Section 75W to Project Approval (MP10_0050)

Westmead Millennium Institute, Westmead Health Campus

Submitted to Department of Planning and Infrastructure
On Behalf of Westmead Millennium Institute for Medical Research

September 2013 ■ 13254

WEST ELEVATION

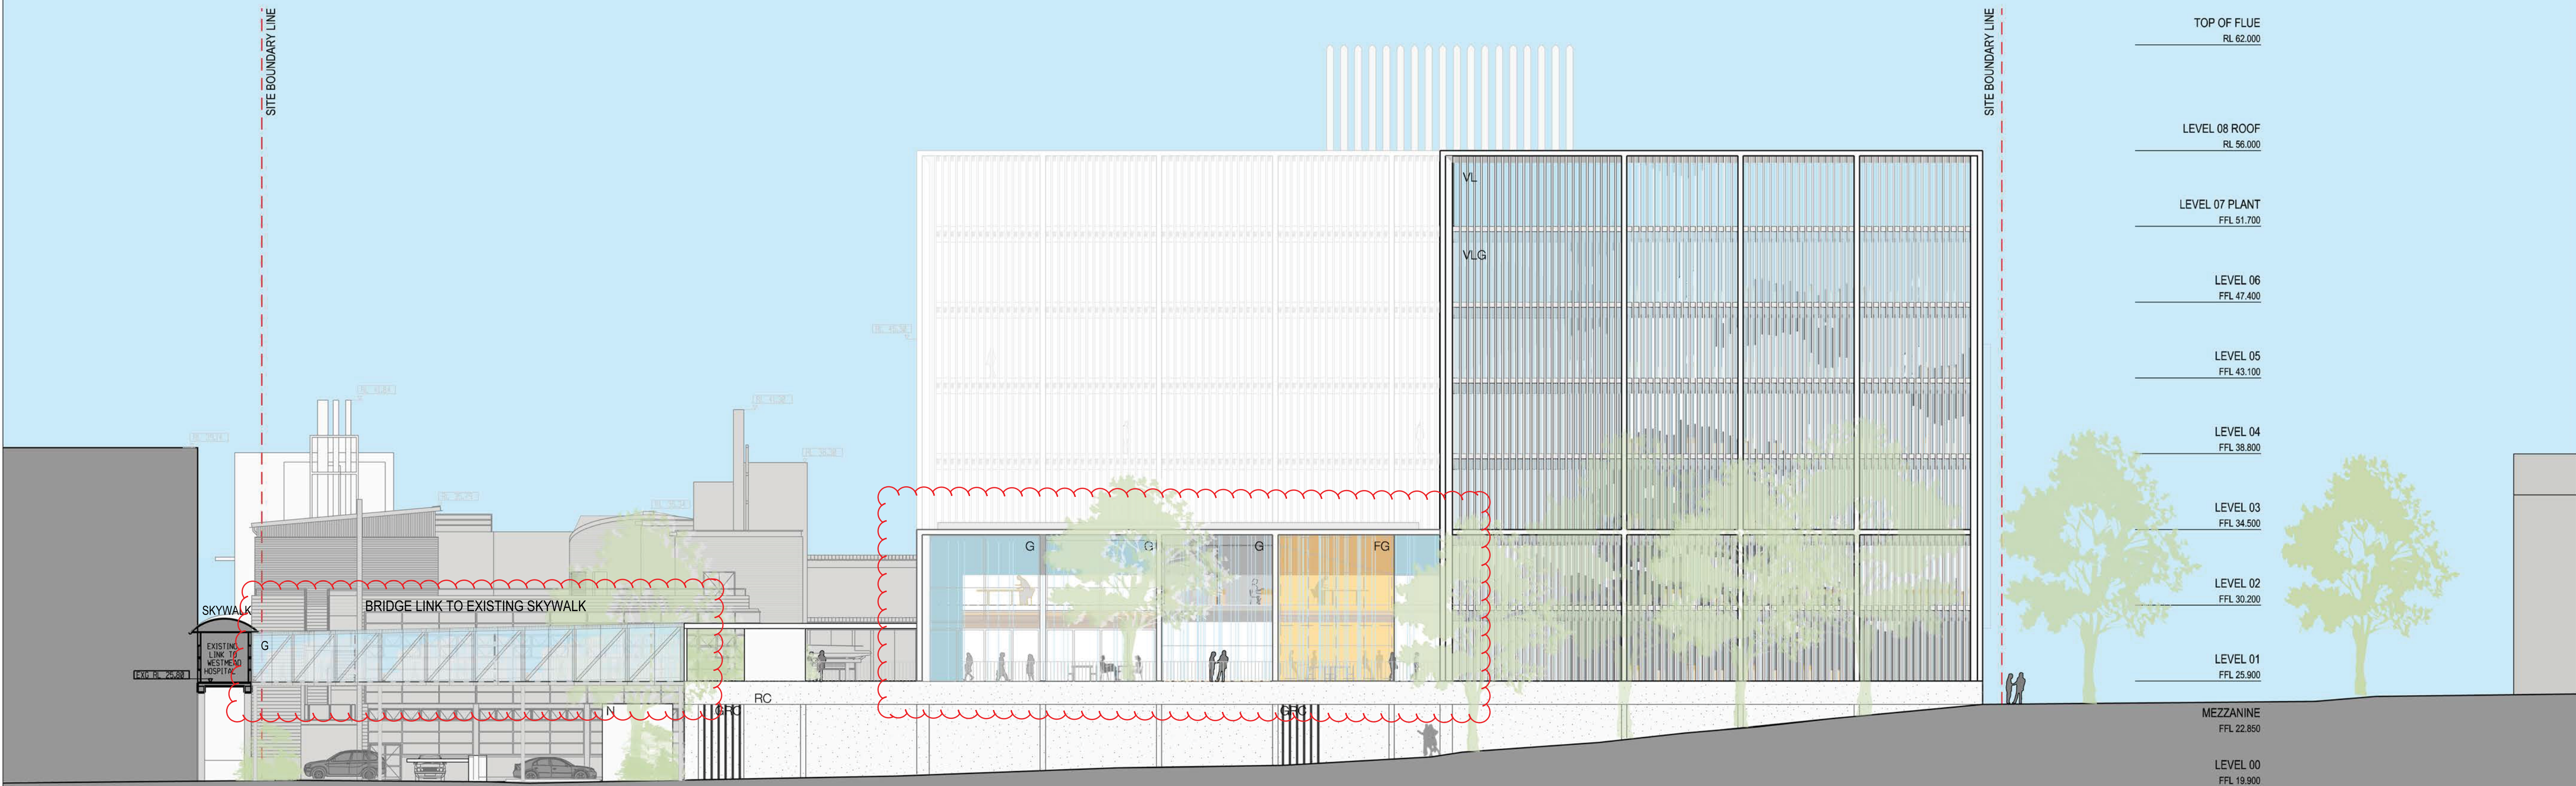
West elevation

- The alignment of facade line has been modified at the lower levels to be consistent with the internal planning layout.

The minor extension to the façade line along with western elevation provides for a more useable café area that is protected from the elements and able to be used all year round.

EAST ELEVATION

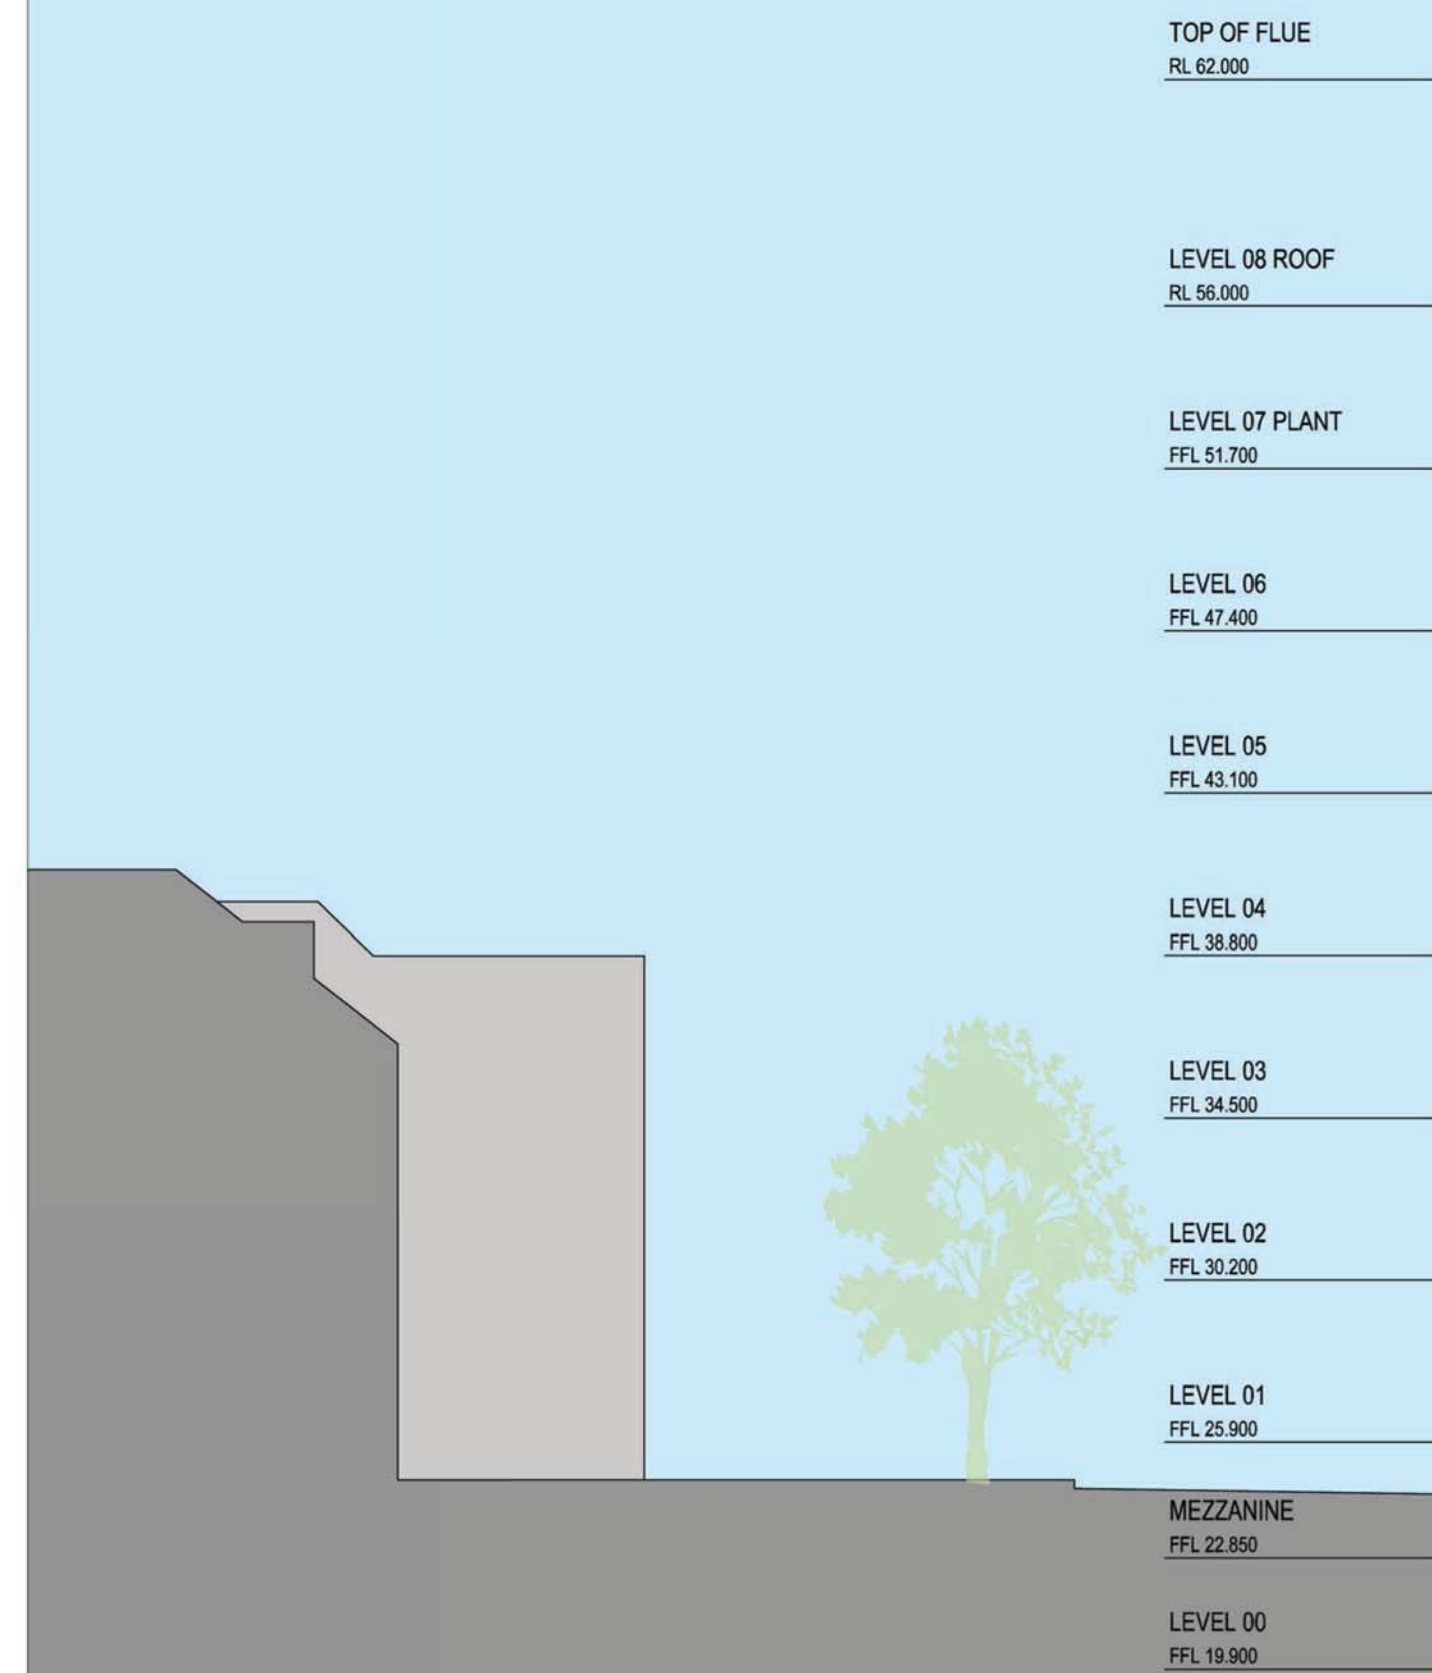
East elevation

- The extent of glazing has been reduced with a section of windows at the Eastern and Western ends removed.
